BeforeBricks Limited
3rd Floor 56-90 Paul Street
London
EC2A 4NE

Lawful Development Certificate for a Proposed Use or Development

Development: Lawful development certificate for a proposed loft conversion with rear dormer.
Location: 1 Greenwood Avenue Bognor Regis PO22 9EW

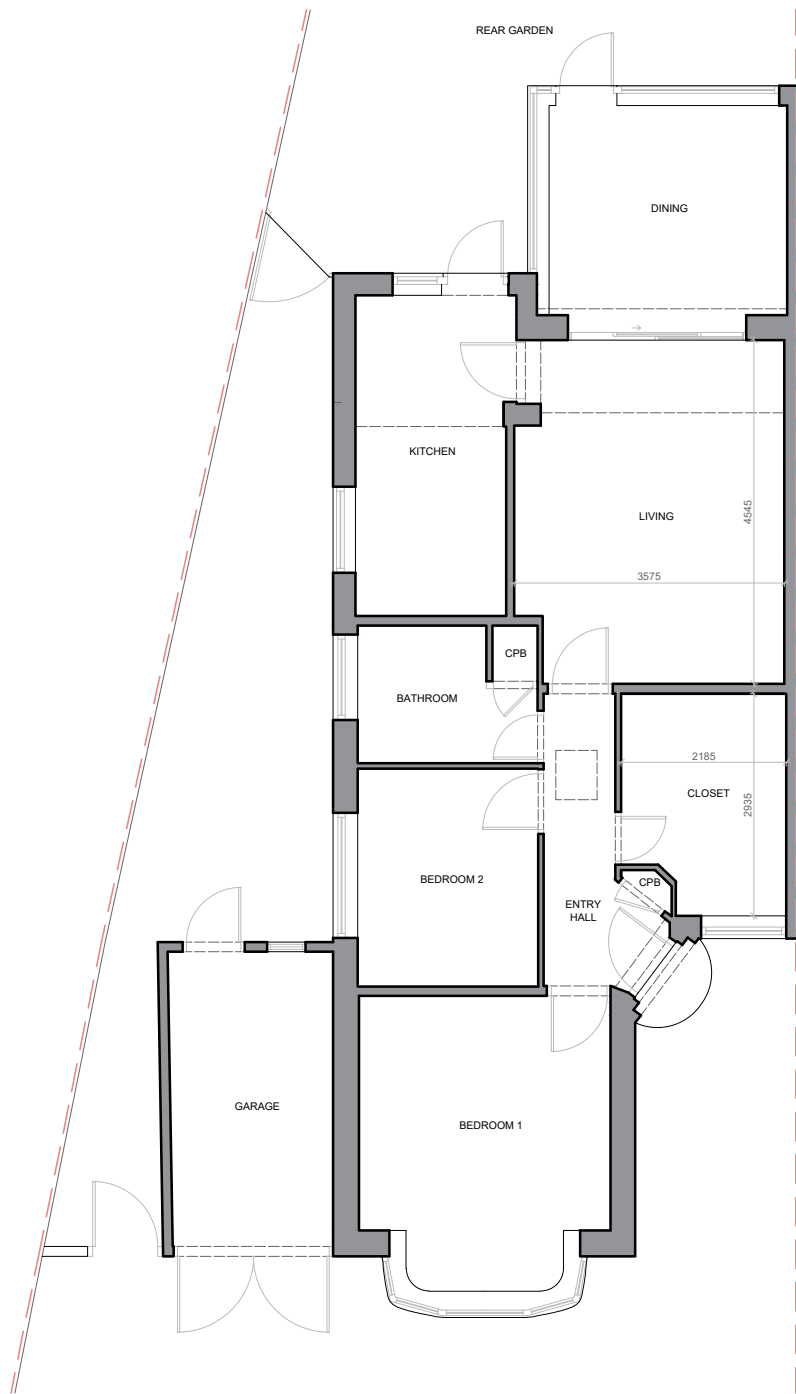
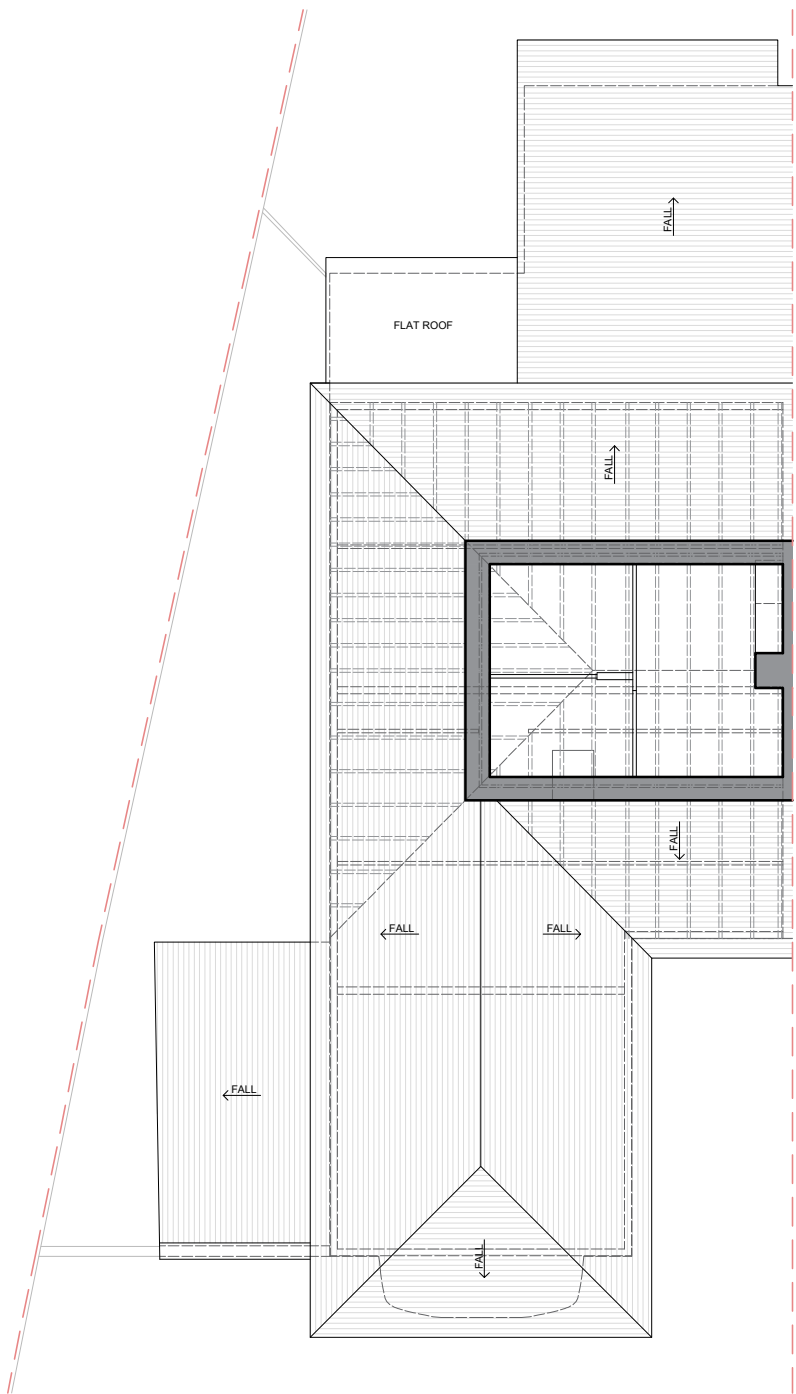
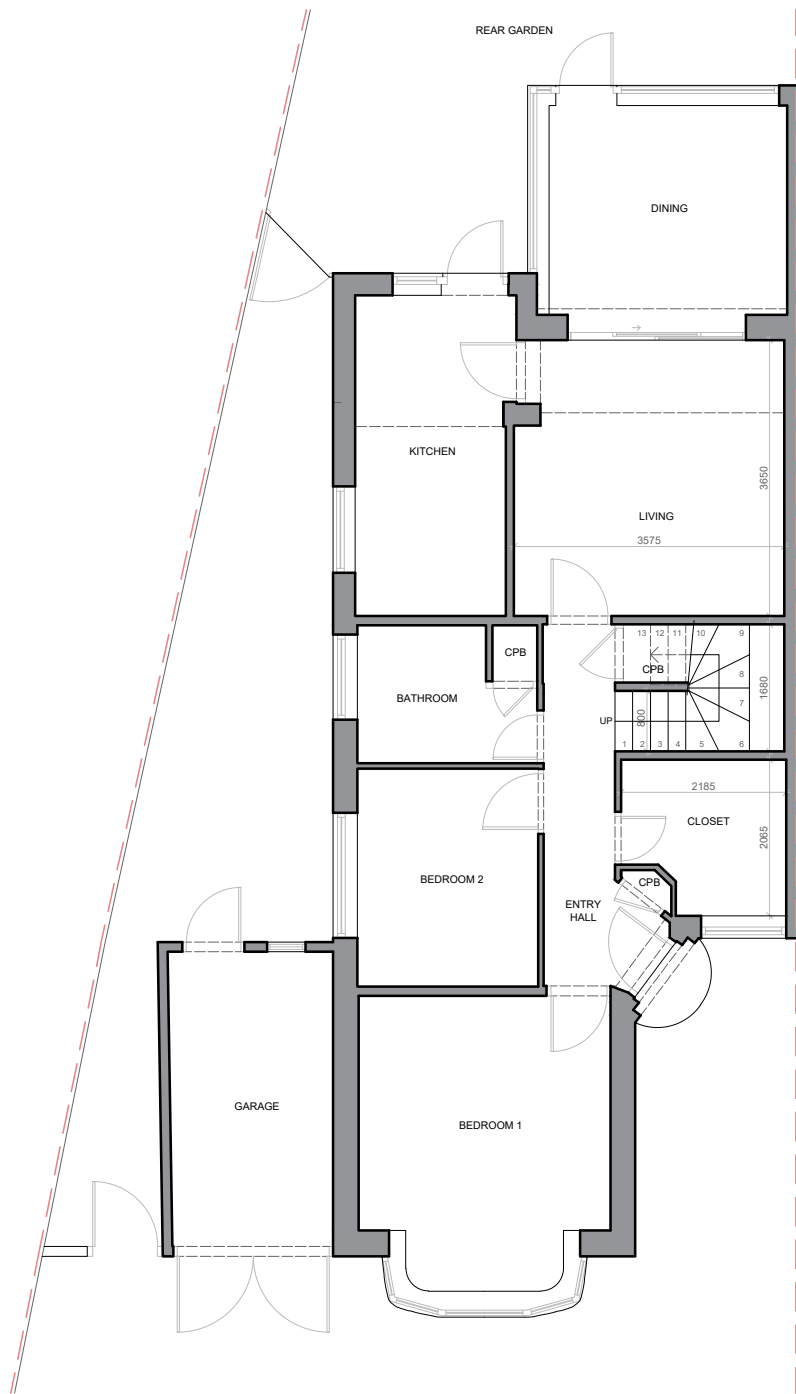
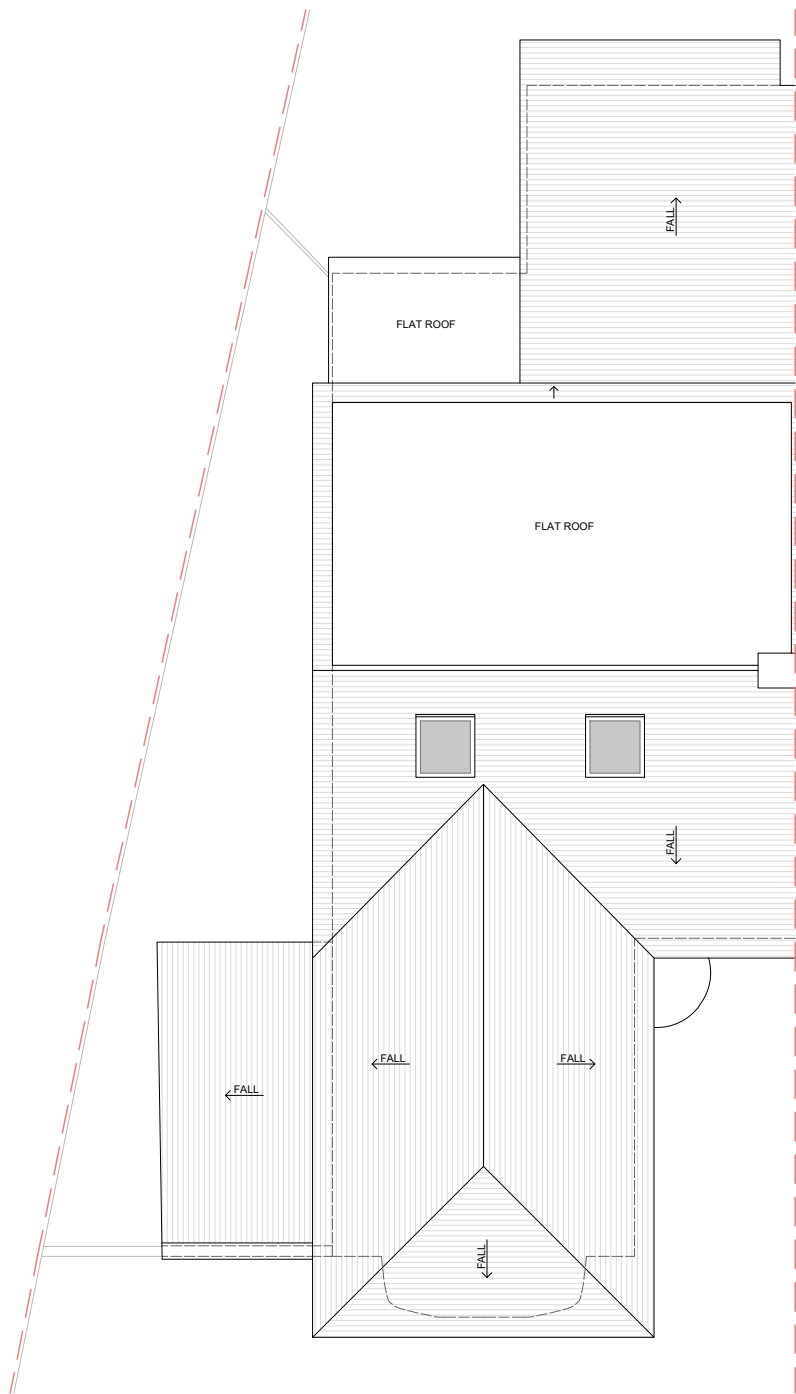
Please label the existing and proposed floor plans as ground and first floor.

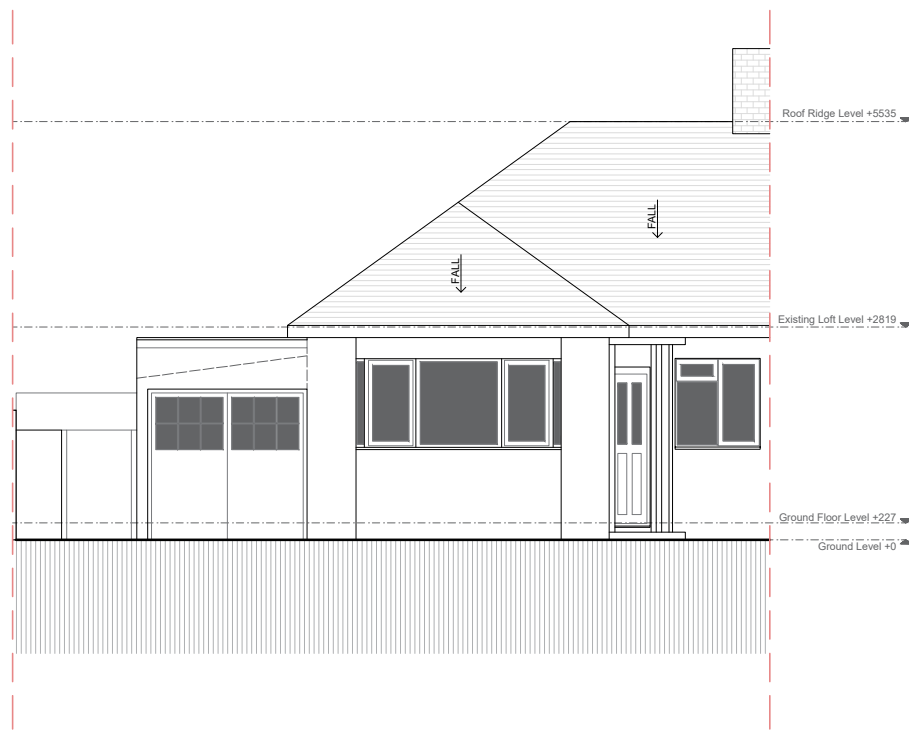
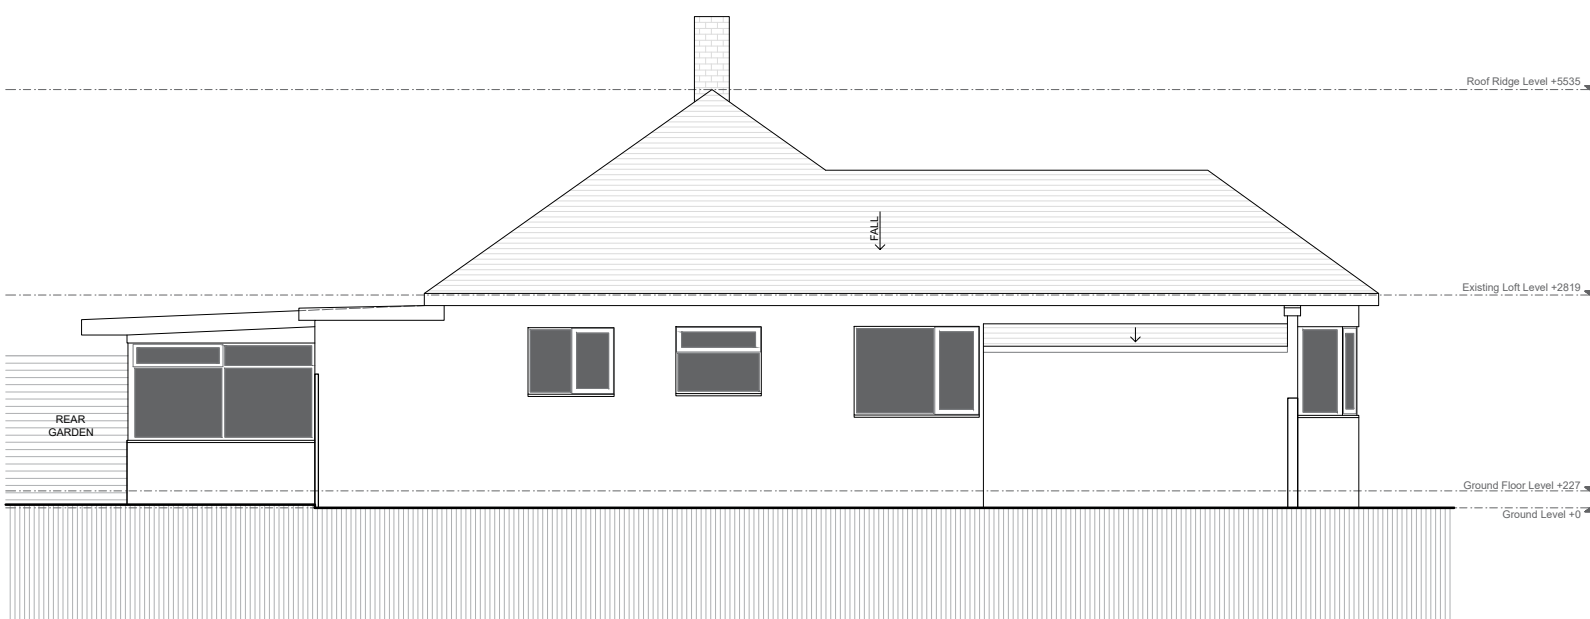
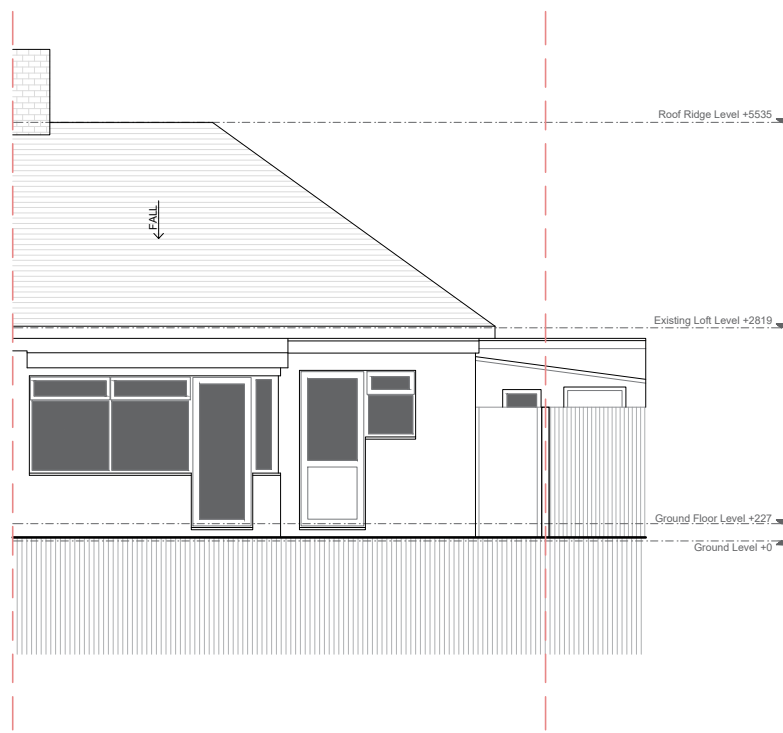
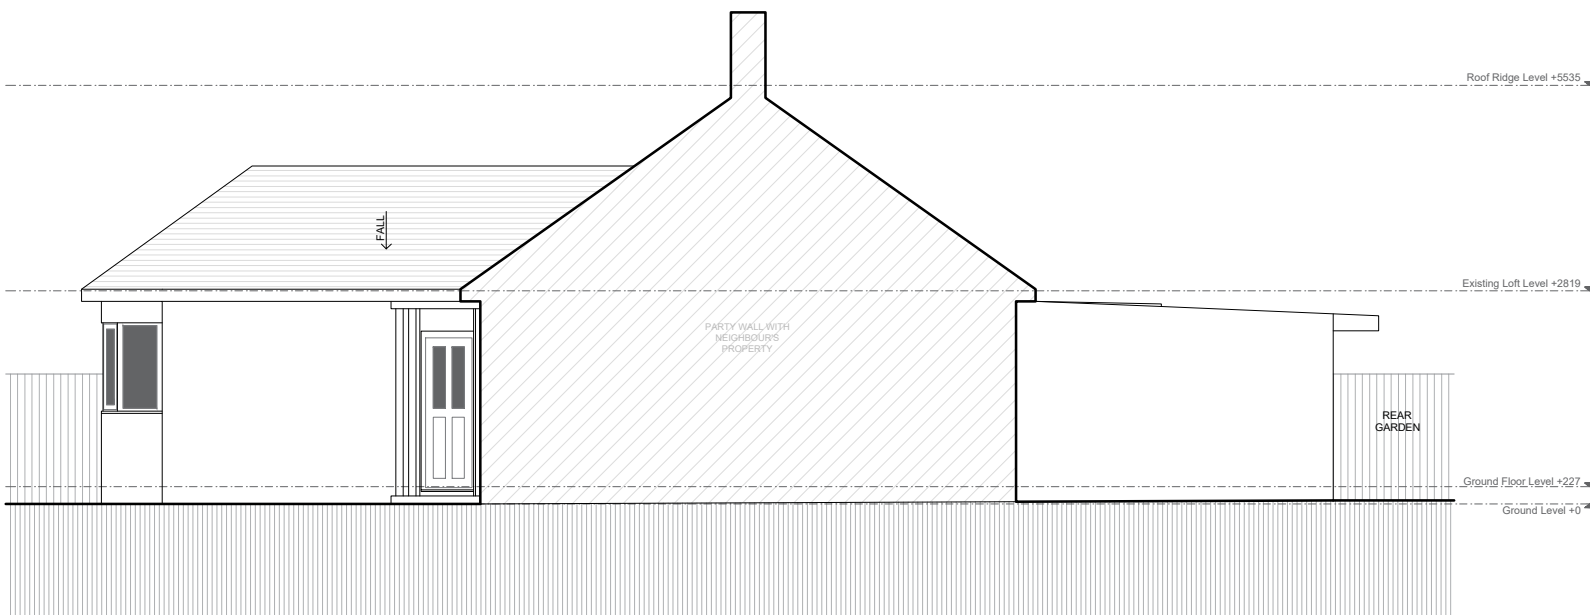
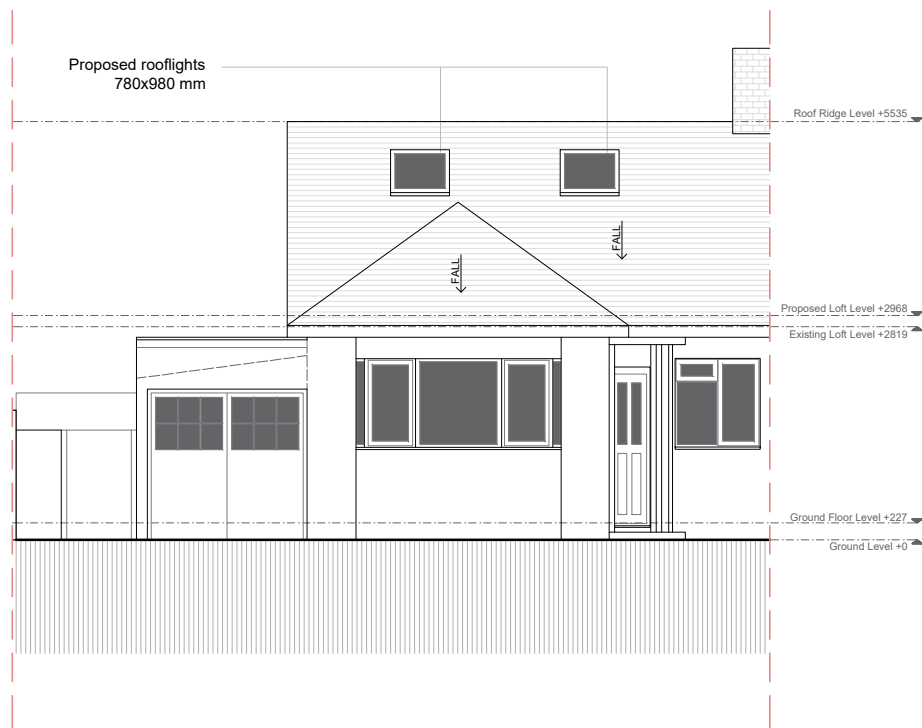
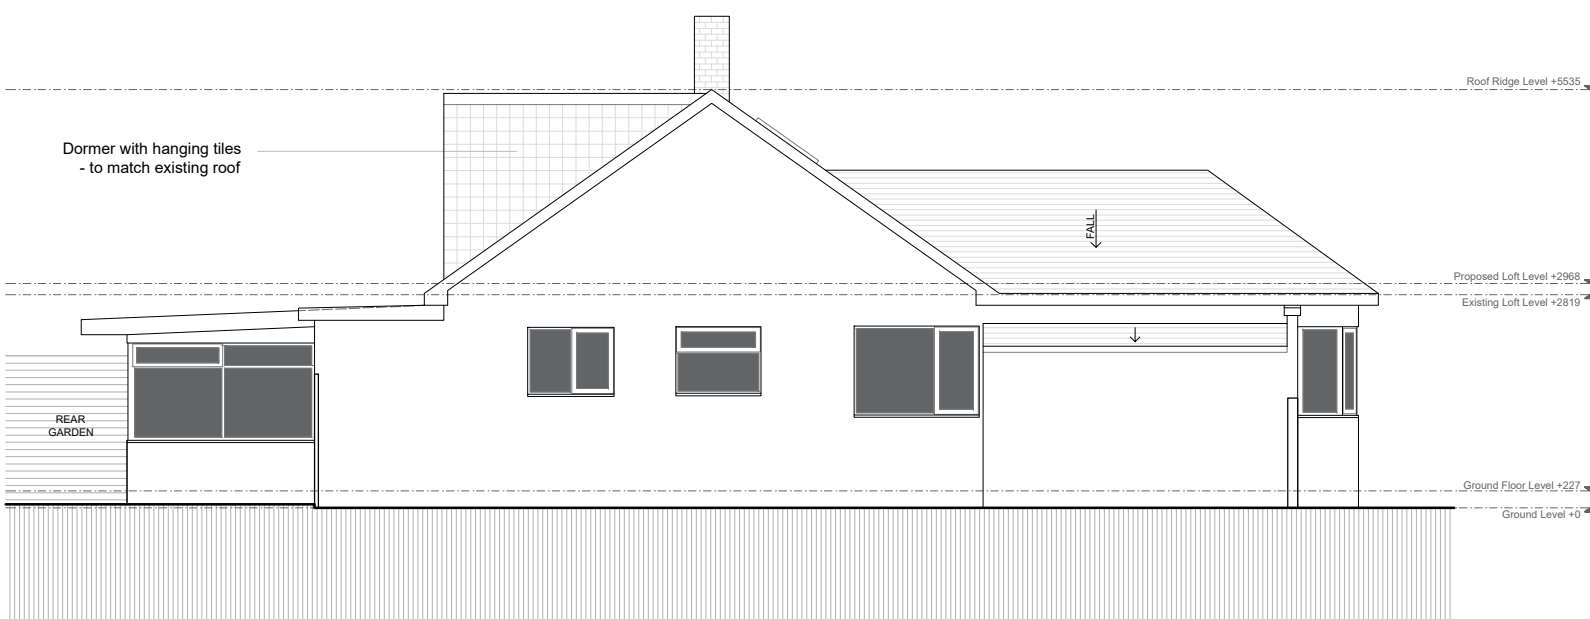
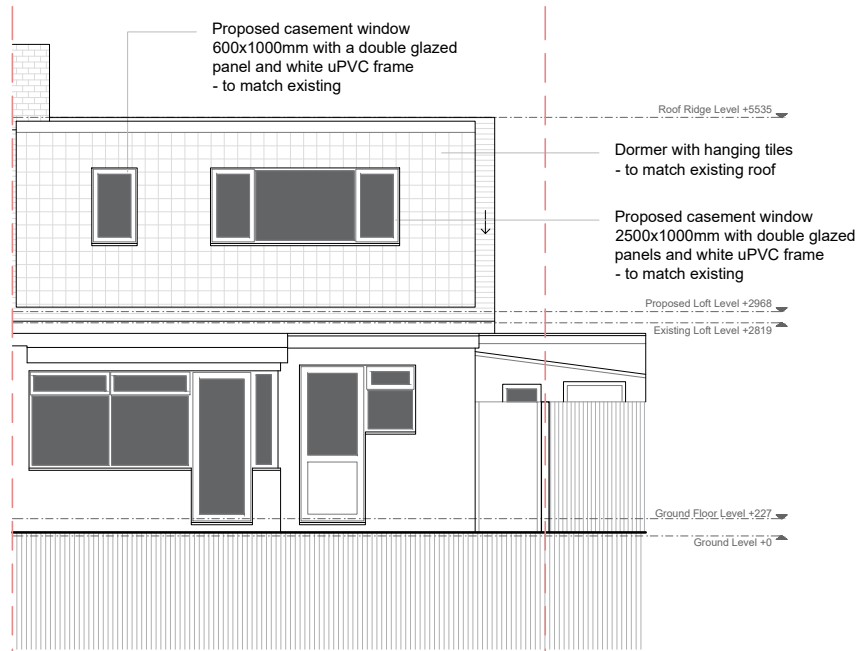
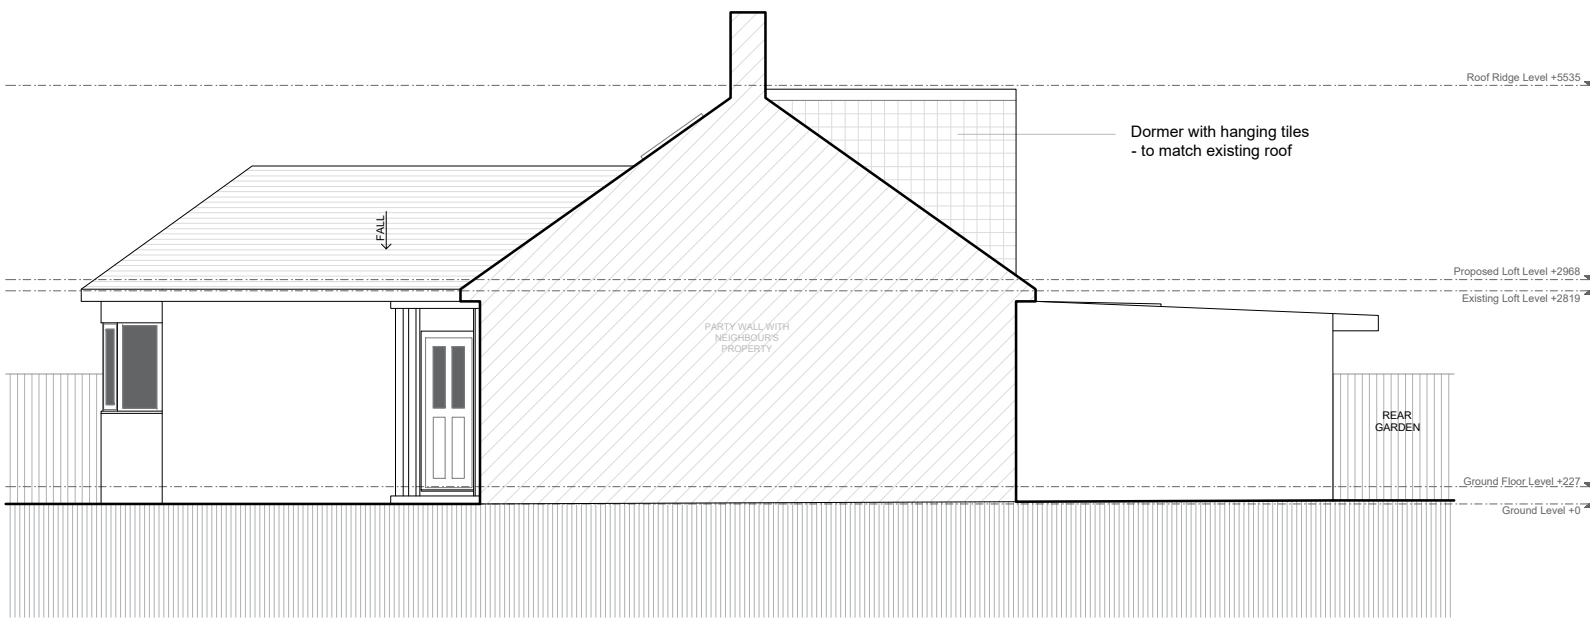
Please label the existing and proposed elevations as north/south/east/west as appropriate.
